Application No: LU/164/21/PL
Site Address: Felix Dancewear 39 Beach Road Littlehampton BN17 5JA
Description of works: Part change of Use from office/storage on first floor to 1-1 bed flat (resubmission following LU/100/21/PL). This site may affect the setting of a listed building & is in CIL Zone 4 (Zero Rated) as flats.

OWPC37643

PROPOSED FIRST FLOOR

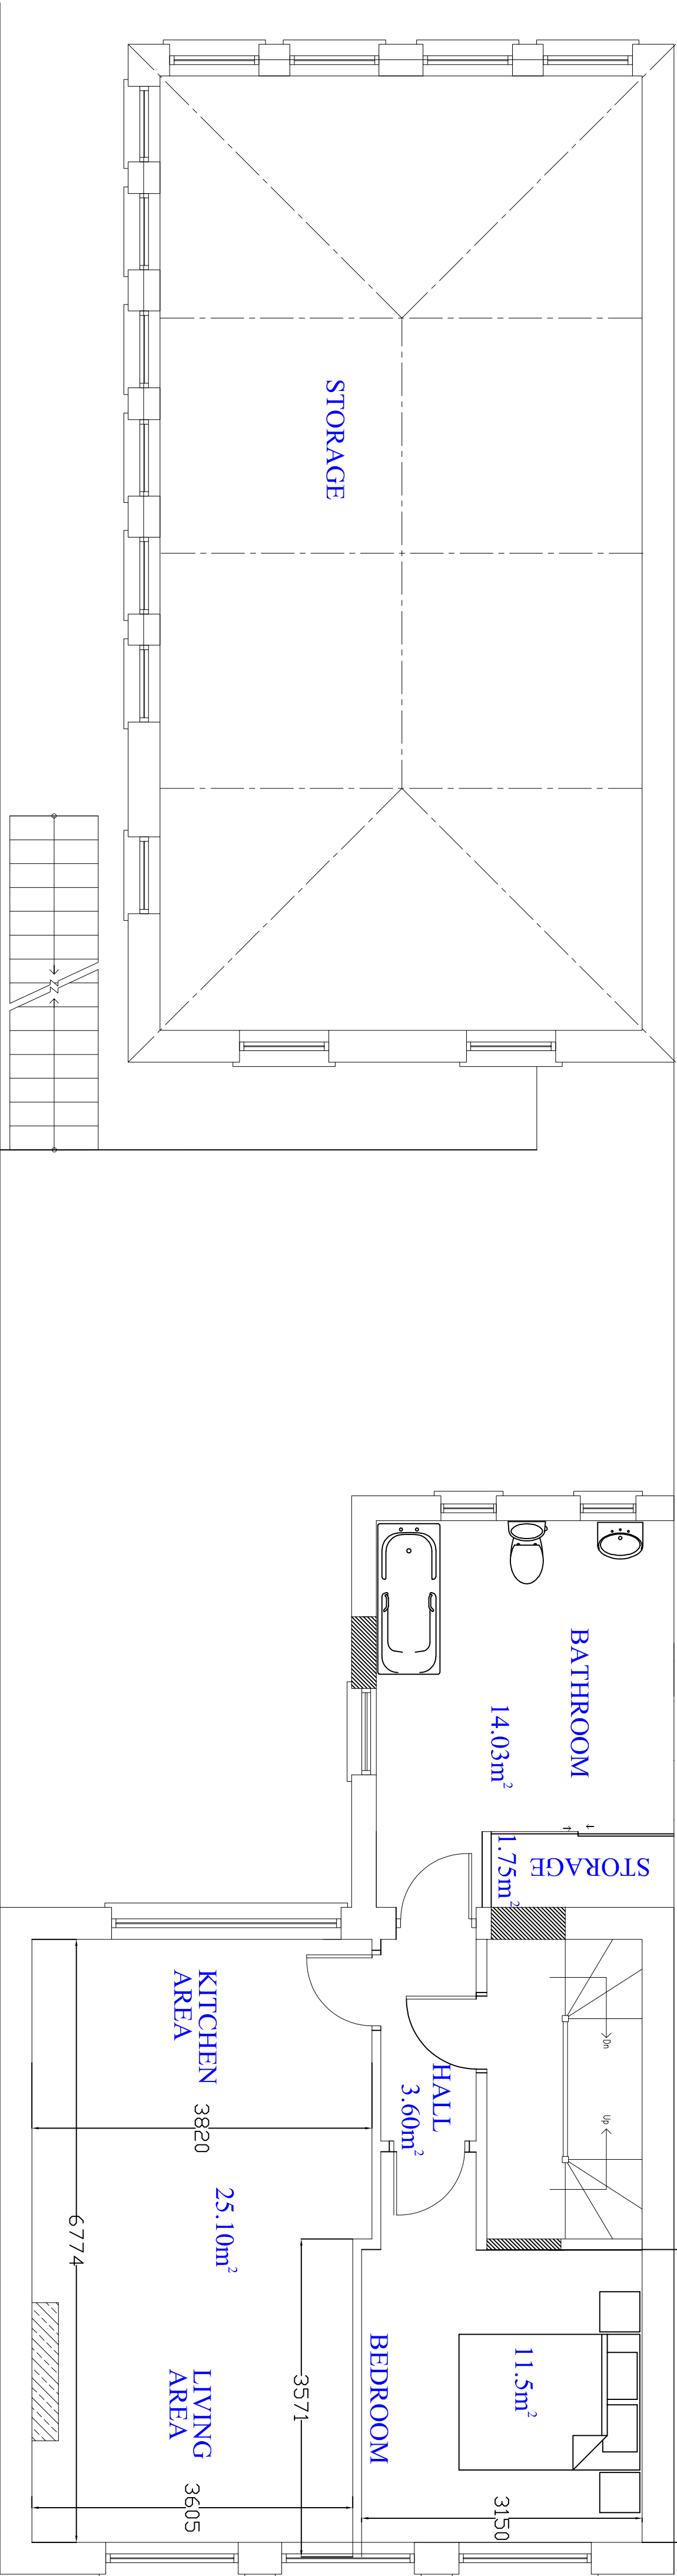
The Town Council's Planning and Transportation Advisory Group considered this application at their meeting held on Monday 21st June 2021 and object to the application. Objection maintained on the grounds that the proposal does not conform to internal space standards (Local Plan Policy DDM2) with reference to the size of the bedroom proposed.
